One Earth Solar Farm

**Draft Statement of Common Ground with Nottinghamshire
County Council**

EN010159/APP/8.3.2

October 2025

## A.6.5 Figures

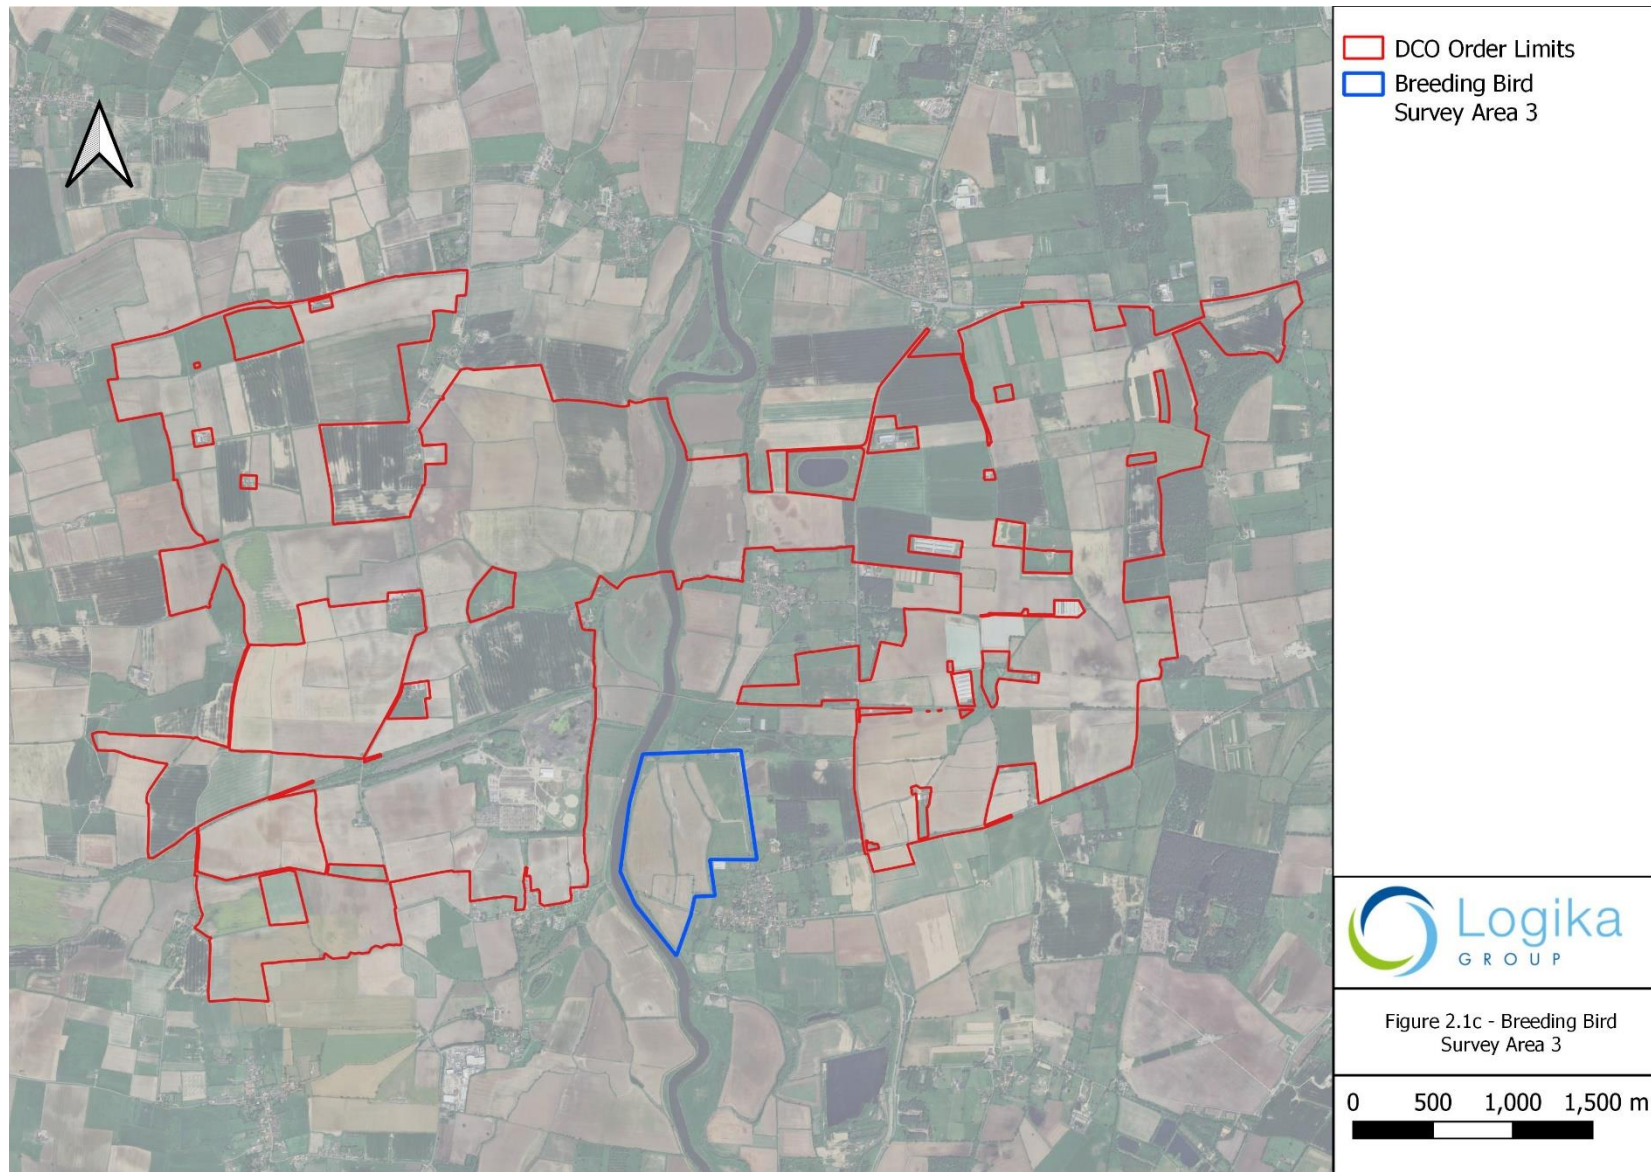
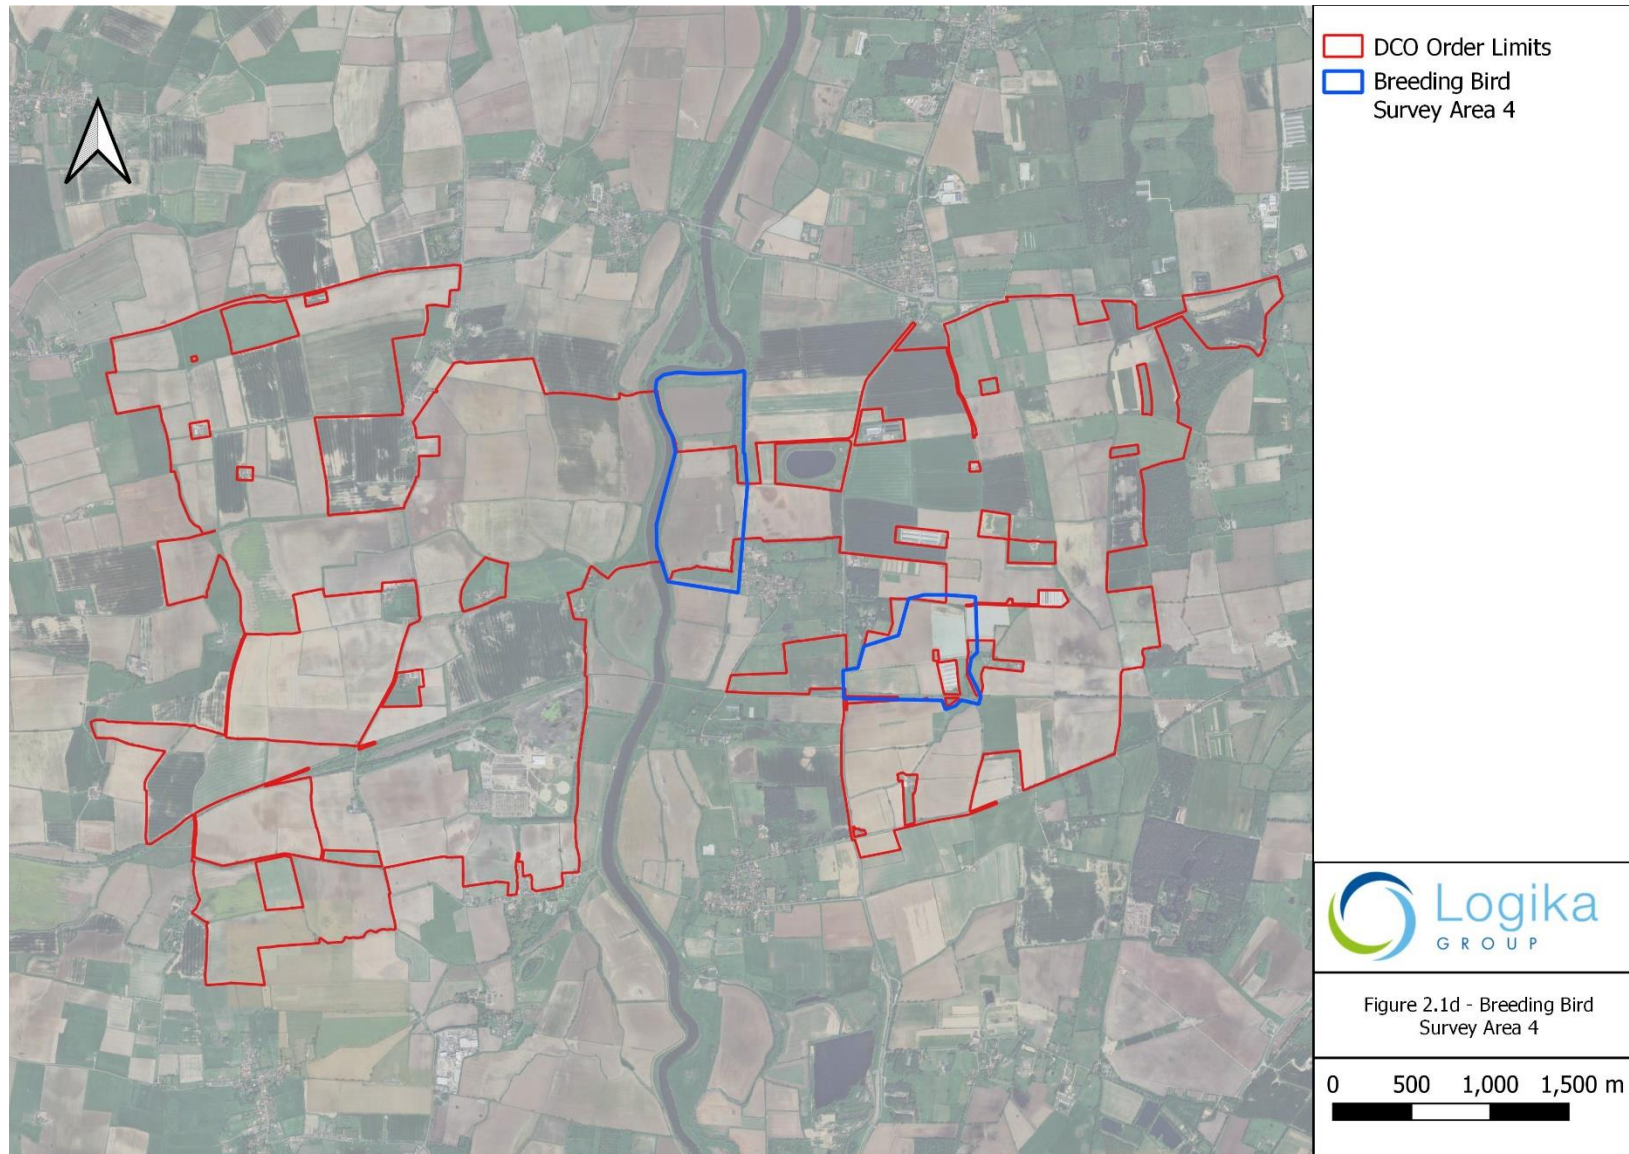
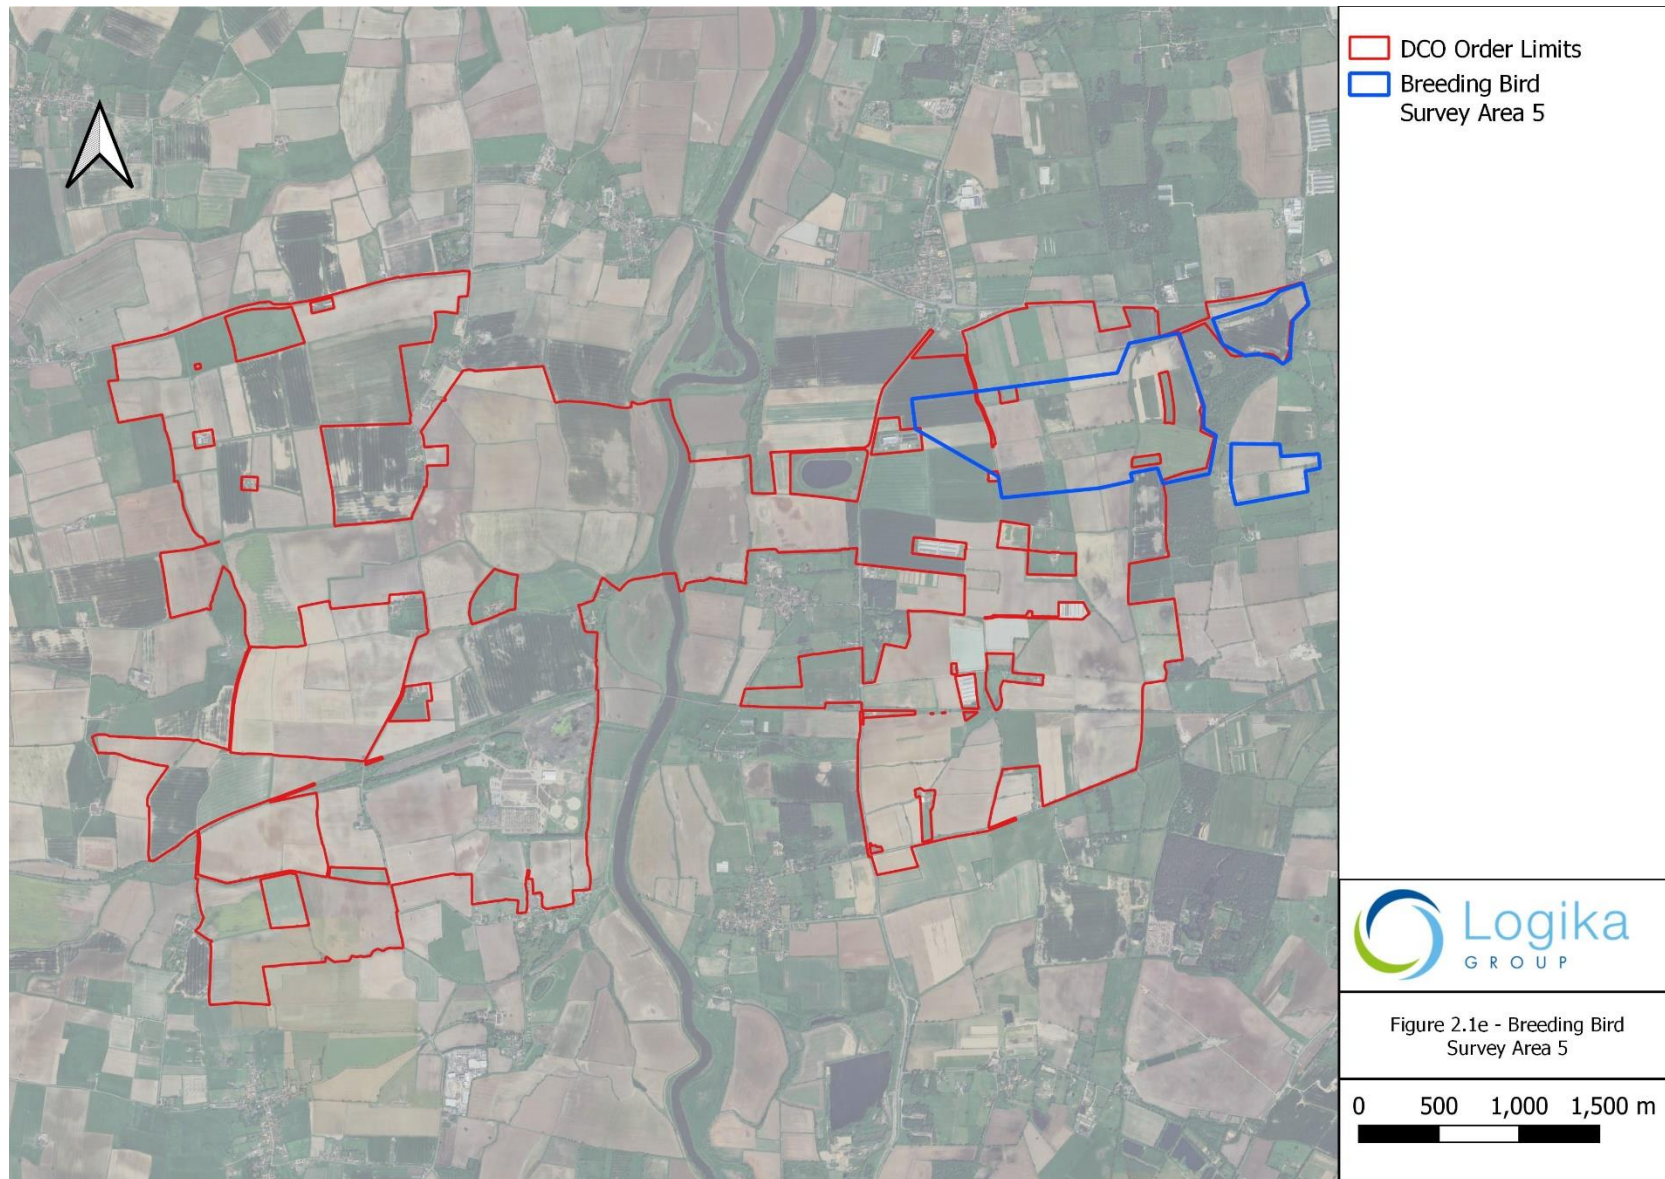
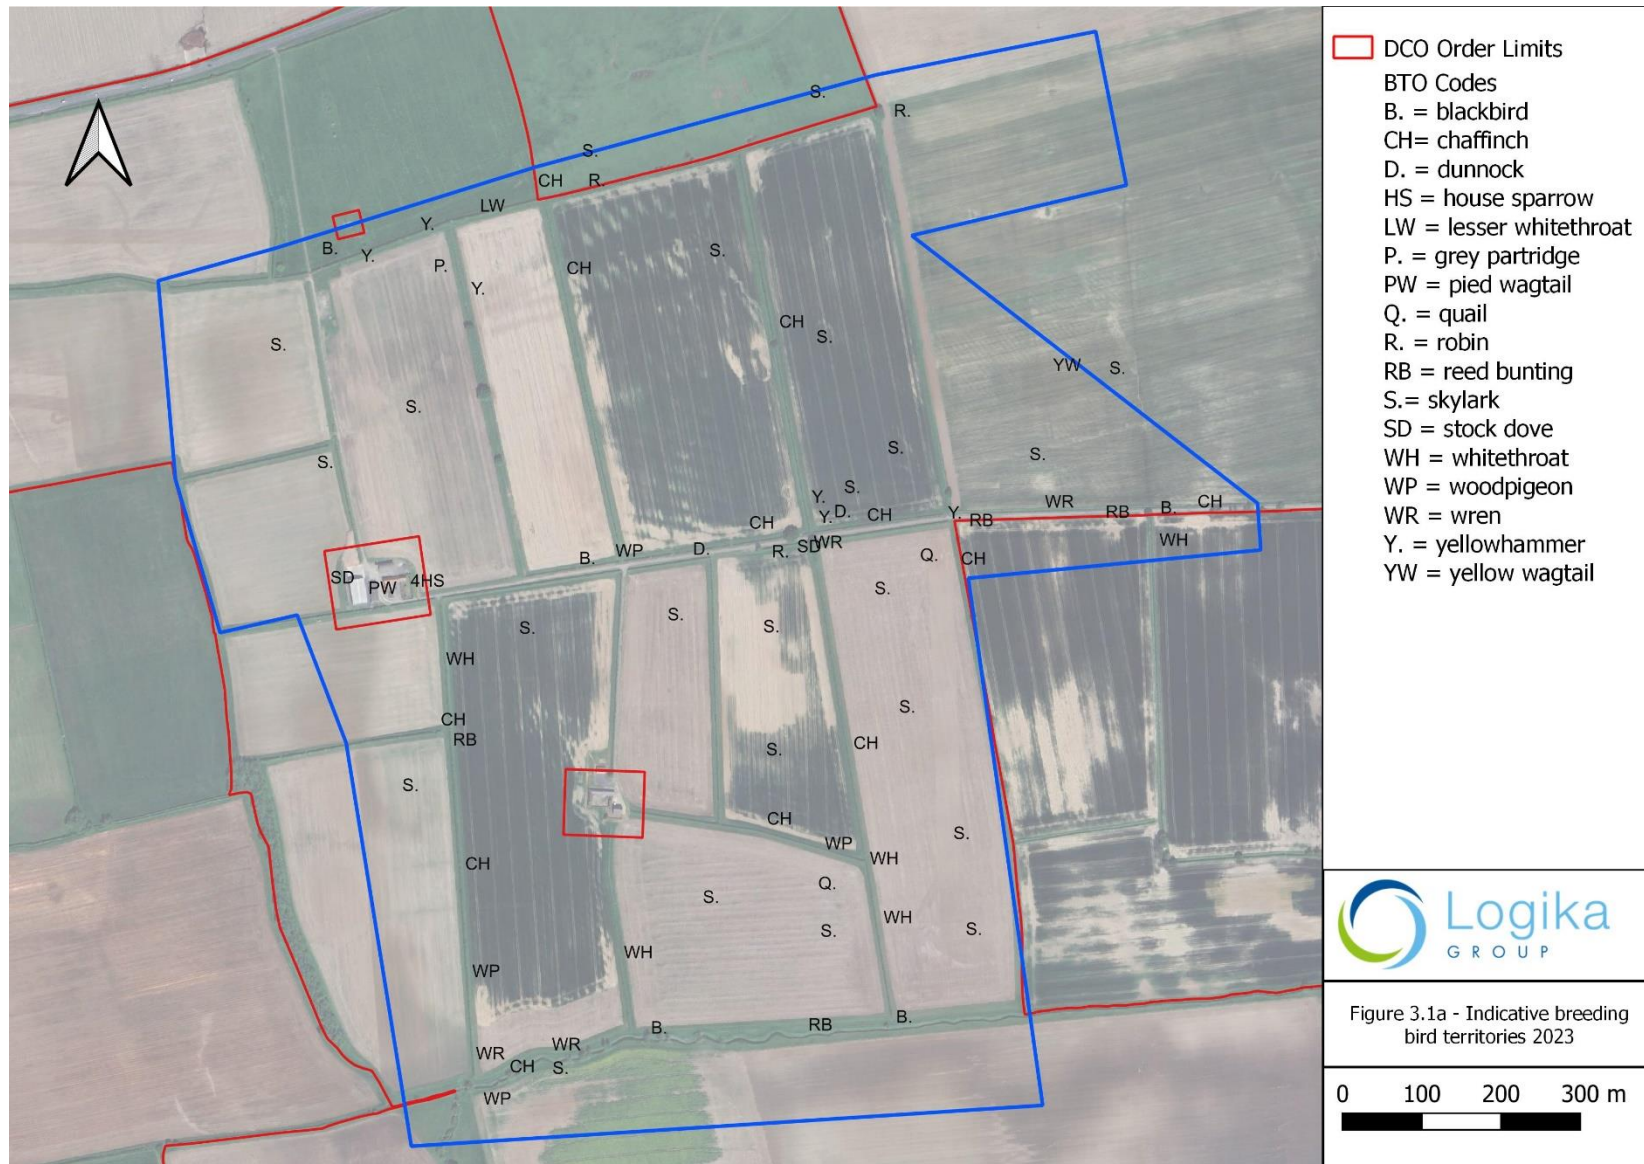
05-04	Survey of Skylarks	Impacts on ground nesting birds, particularly Skylarks, seem to be of greatest concern, but it does not appear that an attempt has been made to estimate how many Skylark territories there will be post-development,	With regards skylark, the mitigation proposed is considered appropriate to provide breeding opportunities to all pairs that may be displaced from the solar array areas.	Under discussion

with mitigation. Furthermore, with regards to para 6.10.92 of the Biodiversity Chapter, further detail is needed of the extrapolation of Skylark territories has been carried out, given only a quarter of the site was surveyed and the extrapolation from 66 pairs to 115 pairs suggests that half the Limit Order is unsuitable for Skylarks, which seems unlikely. In summary, the approach to breeding birds represents a significant area of concern.	An updated extrapolation for skylark was provided at Deadline 1 in Chapter 6 Biodiversity [REP1-023] (see paragraph 6.10.105). Yellow wagtail are considered in the 'Other breeding bird section of Chapter 6 Biodiversity [REP1-023]. This species has been shown to occur within solar farms and should benefit from measures such as the provision of SuDS, temporary ponds and scrapes (see C21 in Table 6.6 Chapter 6 Biodiversity [REP1-023]), and positive management of ditches (see C22 in Table 6.6 Chapter 6 Biodiversity [REP1-023]) due to their feeding preferences.
